Recommendation Report for Planning Permission for Works or Extension to a Dwelling

REF NO: BR/160/18/HH

LOCATION: 33 Southdown Road
Bognor Regis
PO21 2JR

PROPOSAL: Demolition of garage & erection of detached garden room

West Elevation

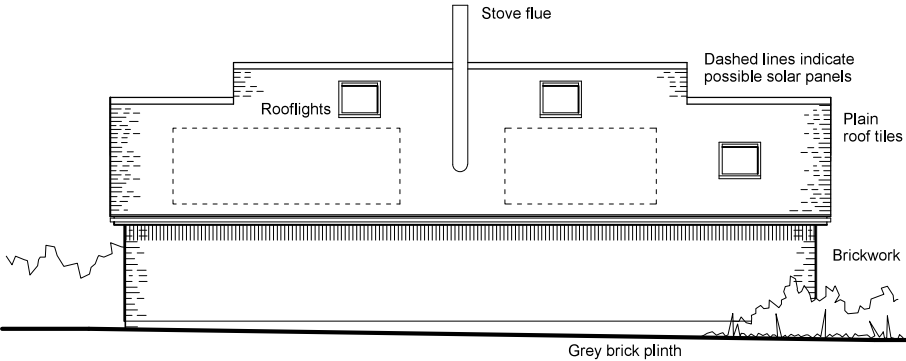
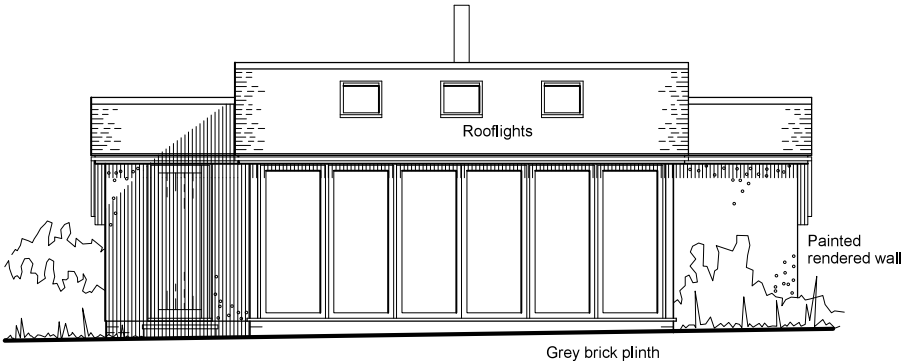
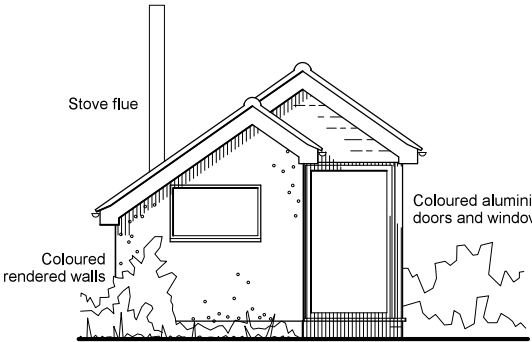
The outbuilding is relatively large and situated adjacent to the boundary of the property to the south. However the eaves level adjacent to the neighbour is low and it rises up away from the neighbour. The building is adjacent to an outbuilding on the property to the south so the impact to the garden to the south is limited.

The building is well designed and appropriate for a domestic setting. Windows would face the property to the north but would not cause overlooking. The building would be visible in the street scene through the narrow gap at the side of the house however no harm to the street scene would arise.

Roof Plan

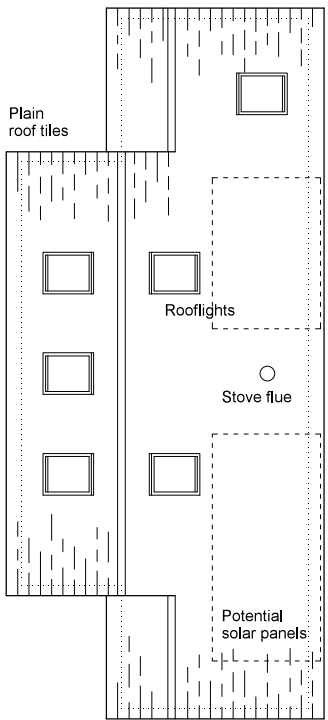
The proposal includes a flue for a stove which would project over the top of the building. Smoke and fumes could arise from this however if a nuisance is caused Environmental Health would have powers to restrict this.
